**OXFORDSHIRE COUNTY COUNCIL’S RESPONSE TO CONSULTATION  
ON THE FOLLOWING DEVELOPMENT PROPOSAL**

**Application no:** 22/01715/OUT

**Proposal:** Erection of up to 500 dwellings with associated access, open space and infrastructure

**Location:** Land South Of Perdiswell Farm Shipton Road Shipton On Cherwell

Access and movement parameter plan

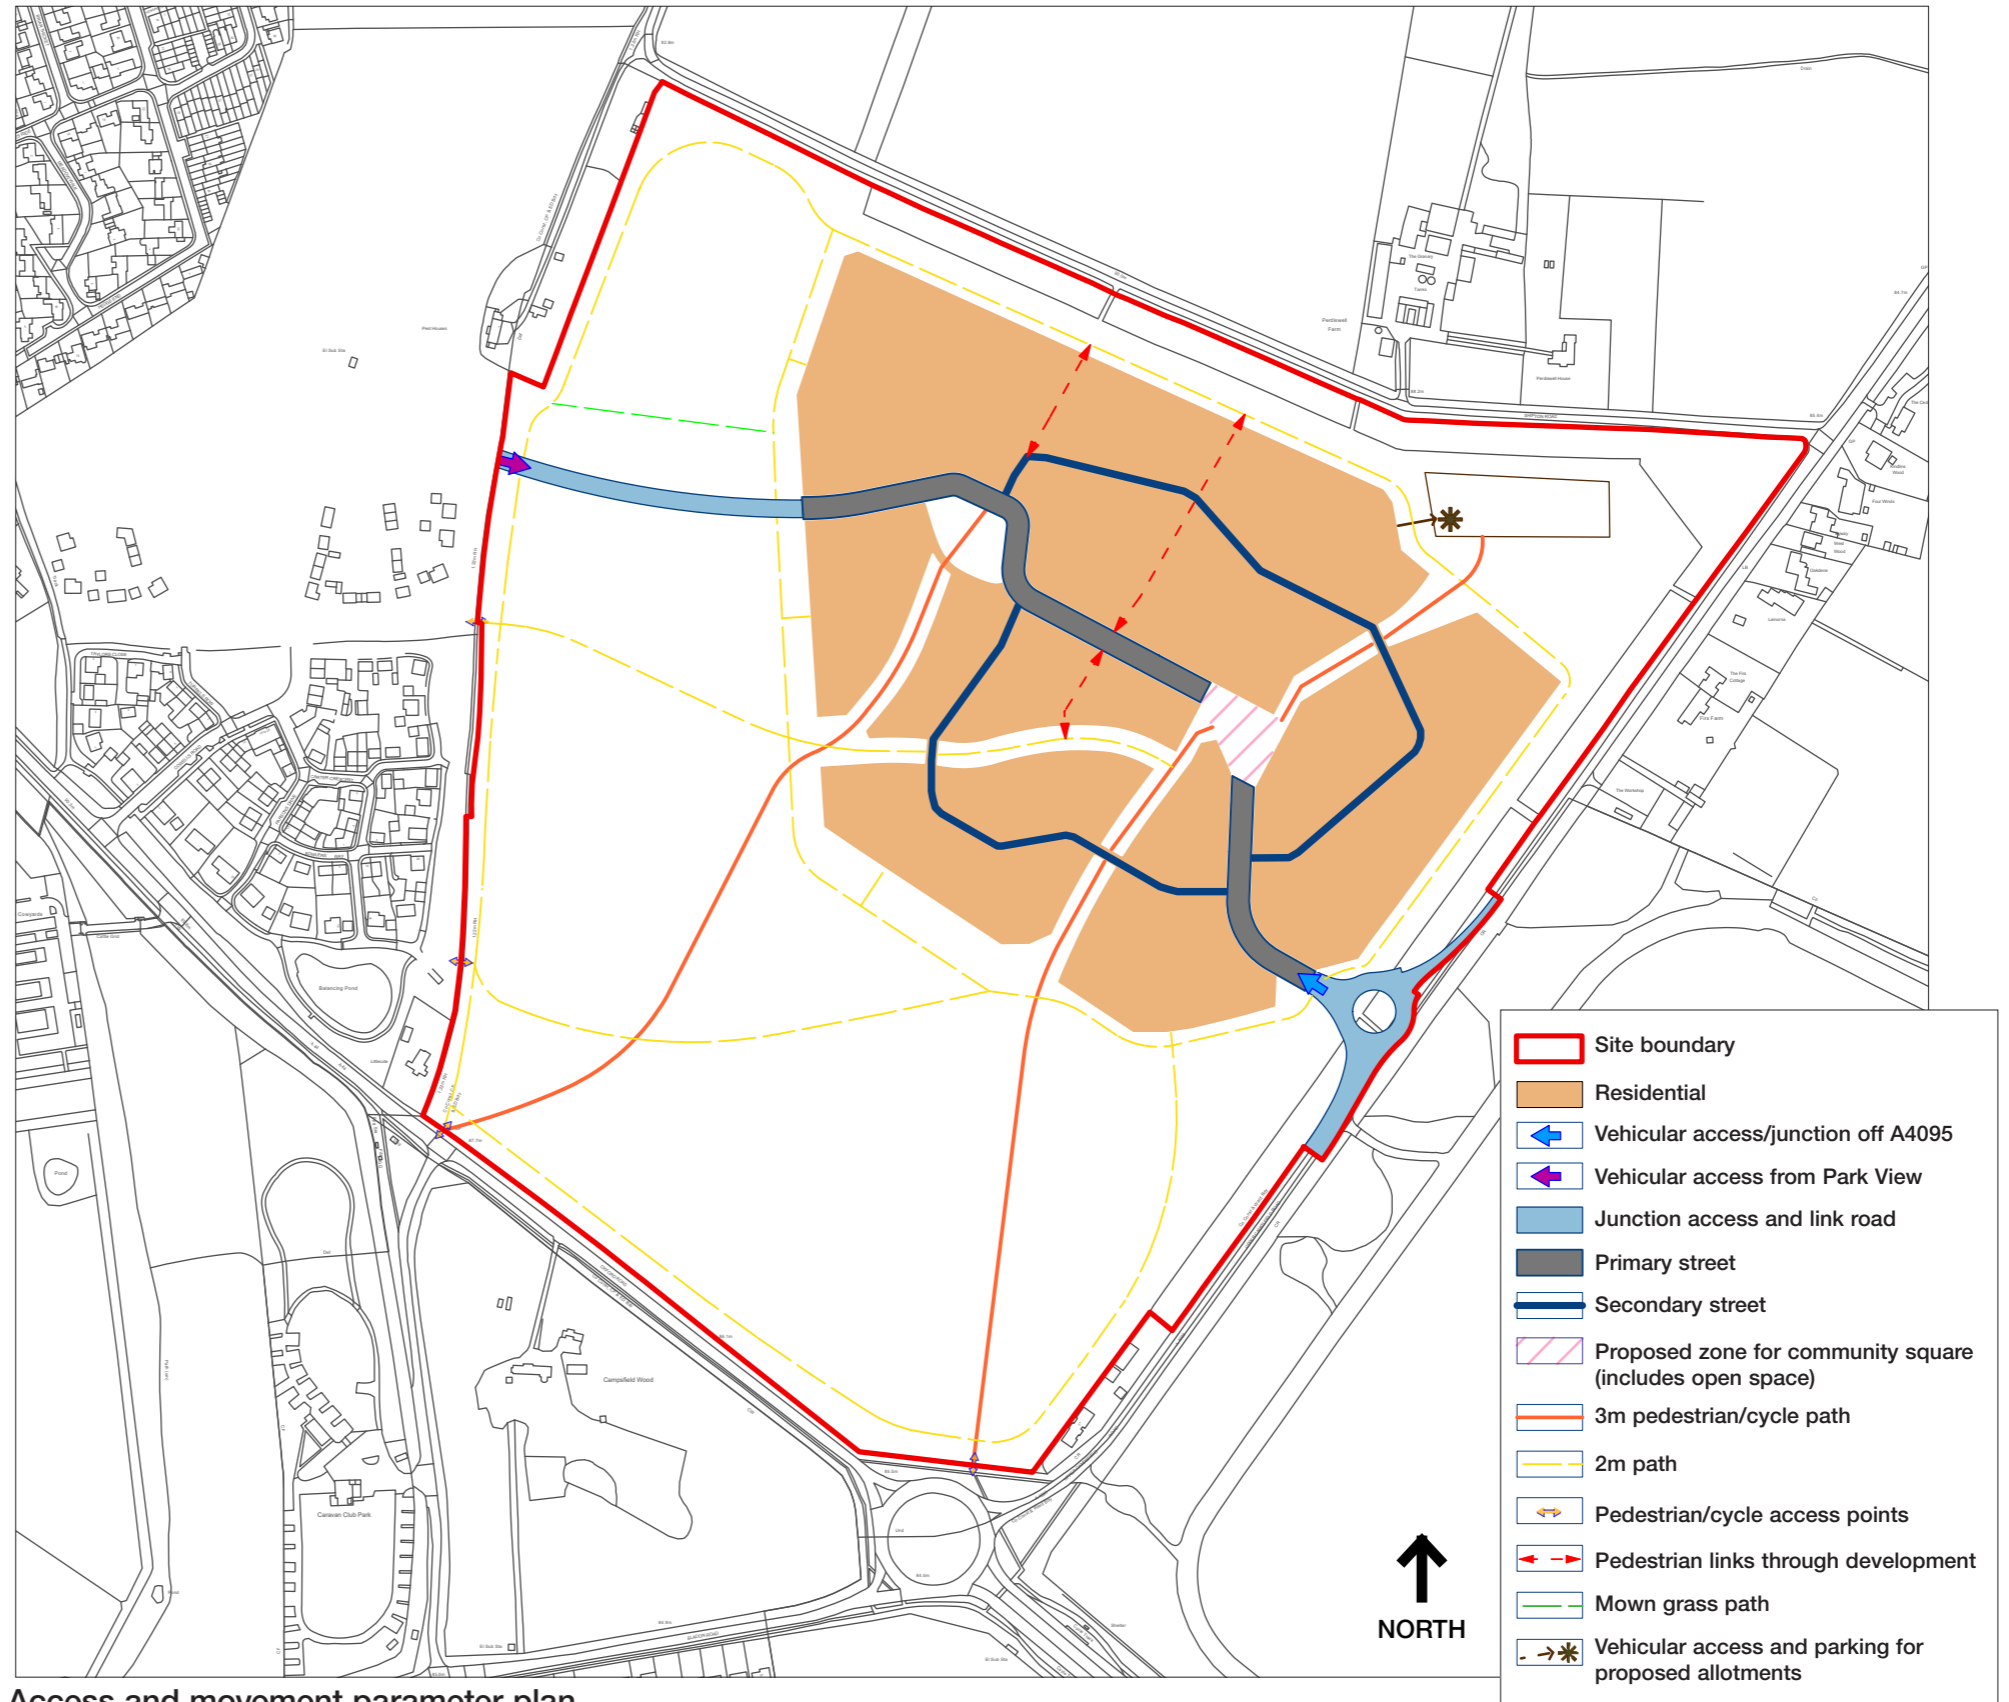
Para 4.3.1 of the TA as well as the Access and Movement Parameter Plan indicate that the development shall be connected to the A44 and Bladon roundabout by a network of 3m wide footways/cycleways. This is welcomed. However, no further detail is availed of how users would cross to the shared footway/ cycleway along the western side of the A44. Are there any plans to provide a crossing point on the A44 to enable residents to access the footway/ cycle way on the opposite side of the road? **(Reason for objection)**
